Final Report - Corrections Required
Application No. ANEX-23-0015

Description : A request by Norris Ranch Joint Venture, LLC, for annexation of 1,834.298 acres into the City of Colorado Springs. The annexation is a part of the overall Karman Line Land Use Plan, which is being submitted concurrently. The Land Use Plan proposes a maximum of 6,500 dwelling units, approximately 45 acres of light industrial, 105 acres of commercial/retail, 100 acres of mixed-use development, and 570 acres of park/open space.

Subject: Karman Line Land Use Plan AKA Norris Ranch, MAPN-23-0002
Colorado Springs, El Paso County, Colorado; CGS Unique No. EP-23-0068

GEOLOGY/ENGINEERING GEOLOGY MAP
KARMAN LINE
SOUTH CURTIS ROAD & DRENNAN ROAD
EL PASO COUNTY, COLORADO
FOR: NORRIS RANCH JOINT VENTURES, LLC

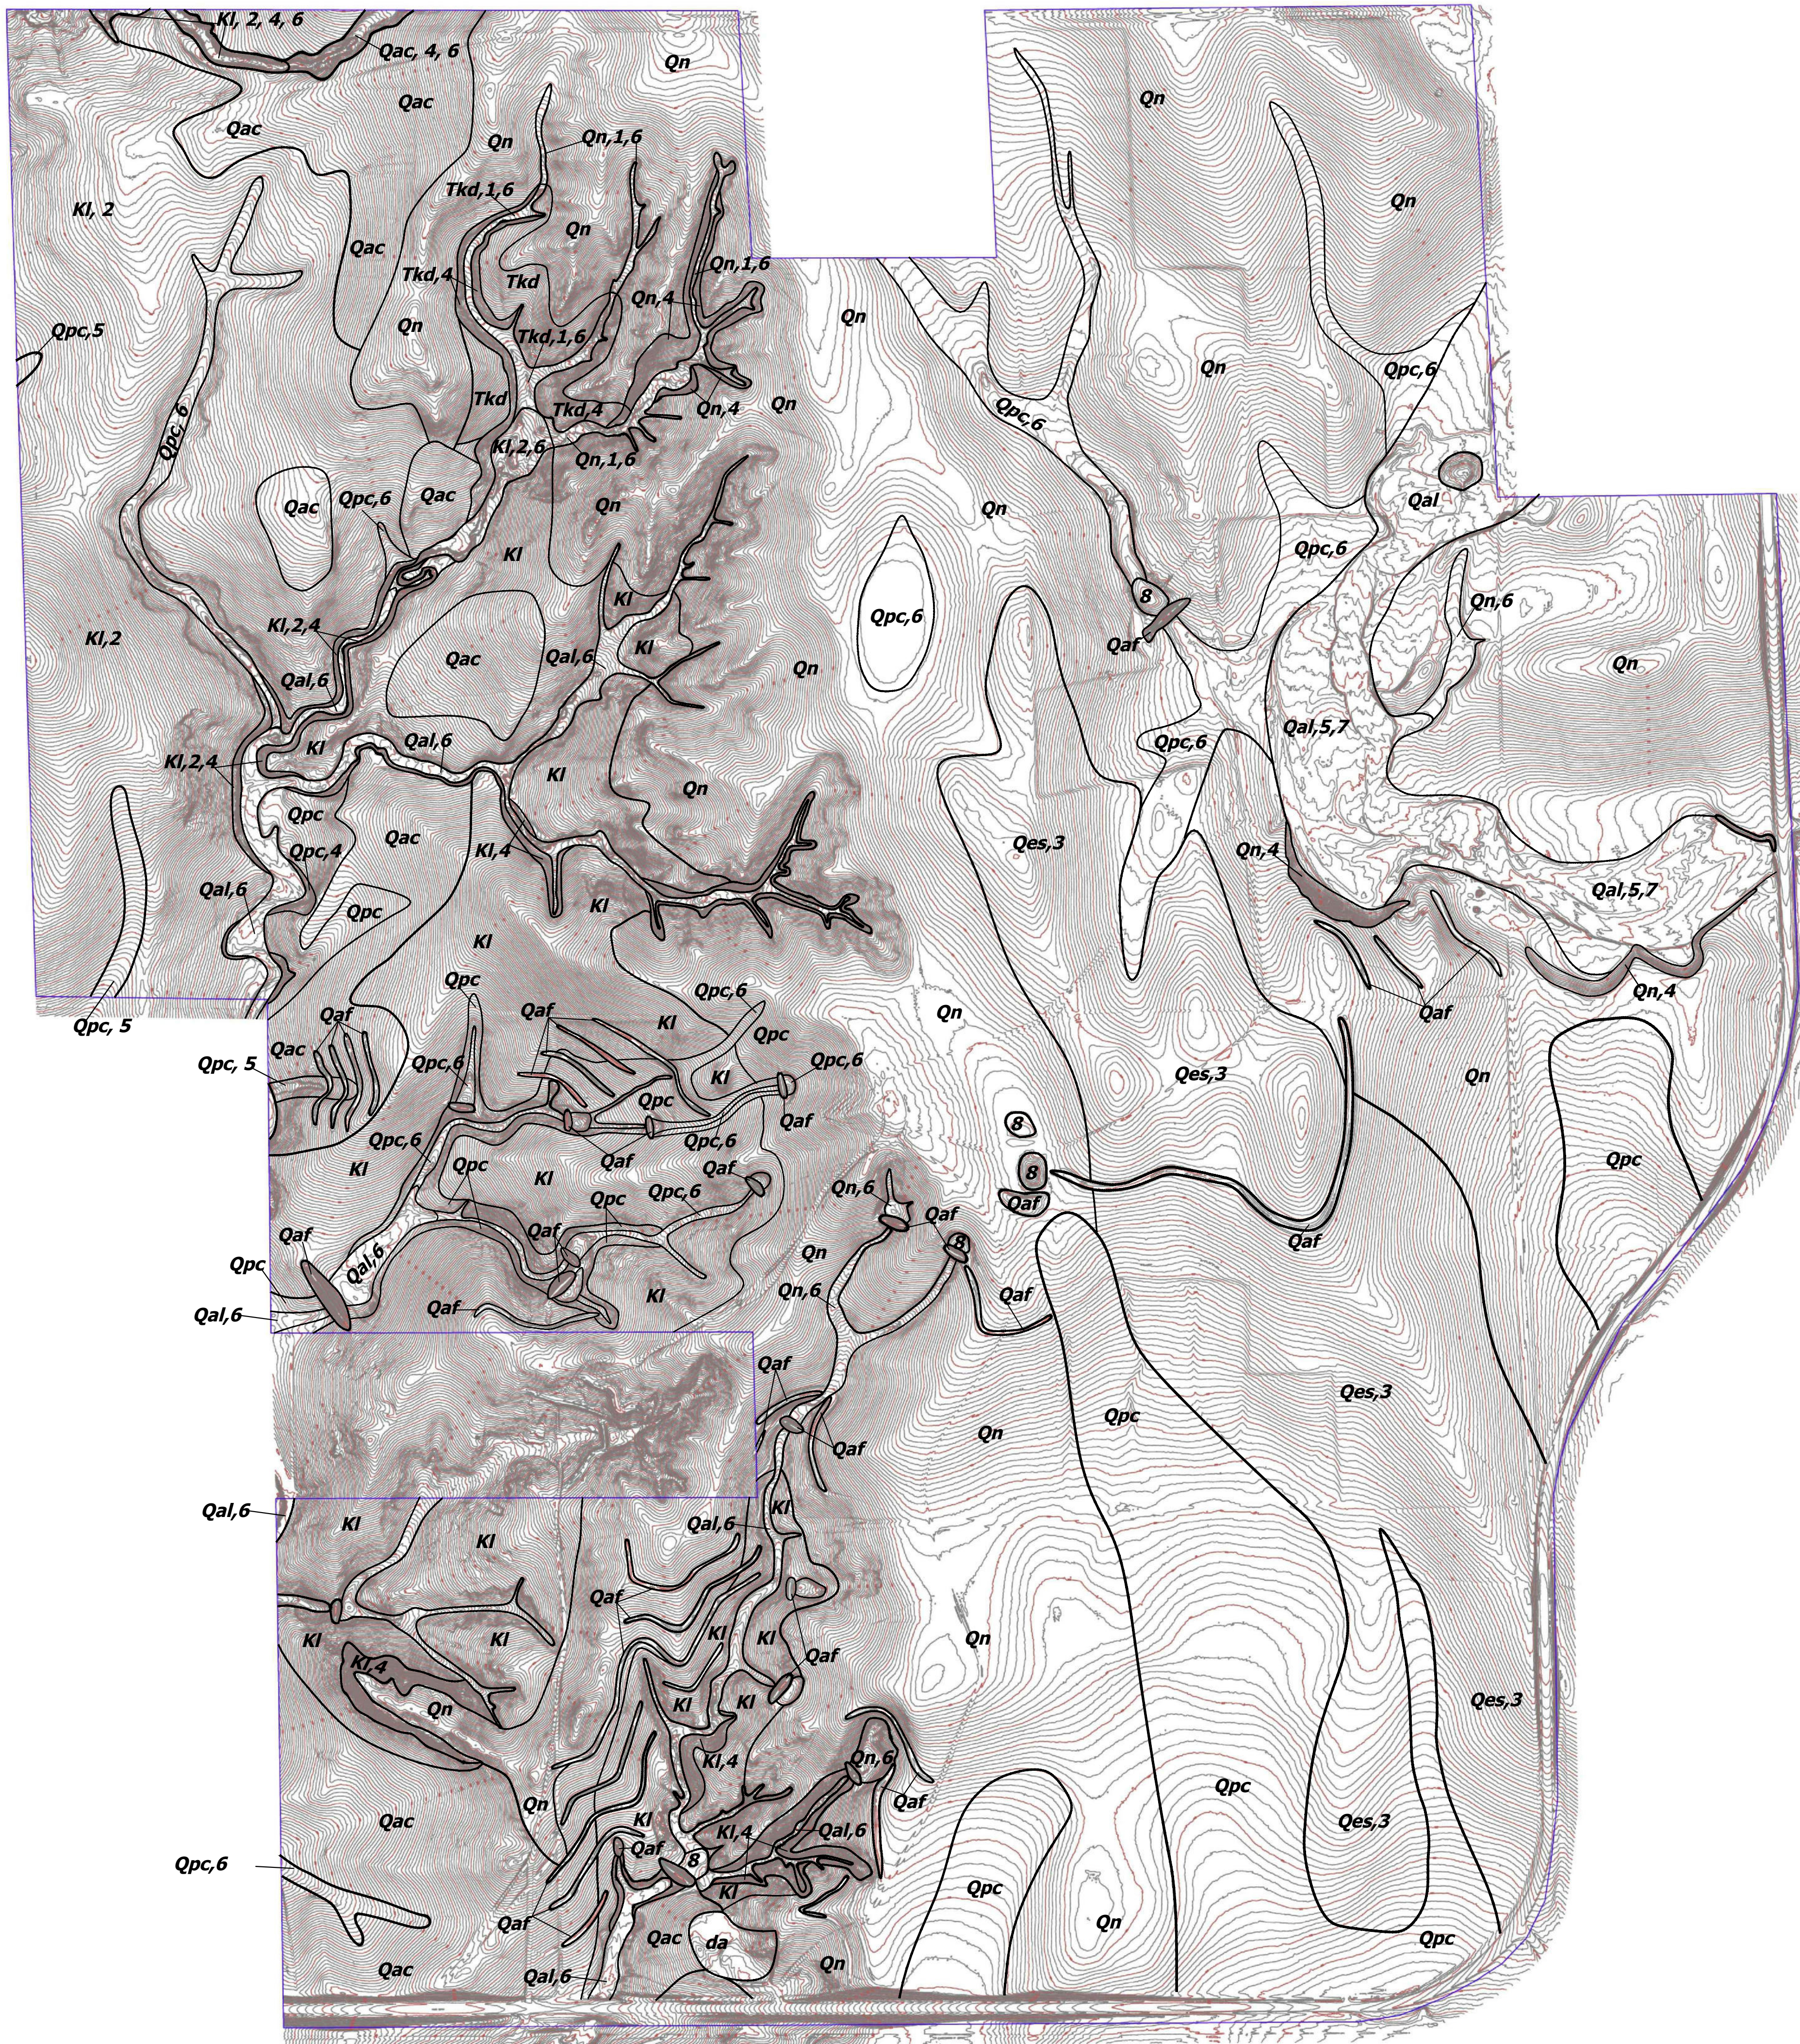
Potentially unstable slope areas. CGS concurs with Entech's recommendation (p. 11), "Building should be avoided on the potentially unstable slopes unless they are stabilized," and with their recommendation of "A

minimum setback of 30 feet from the crest of these slopes.” CGS recommends that site-specific and detailed quantitative slope stability analysis be required to verify this setback as development plans progress.
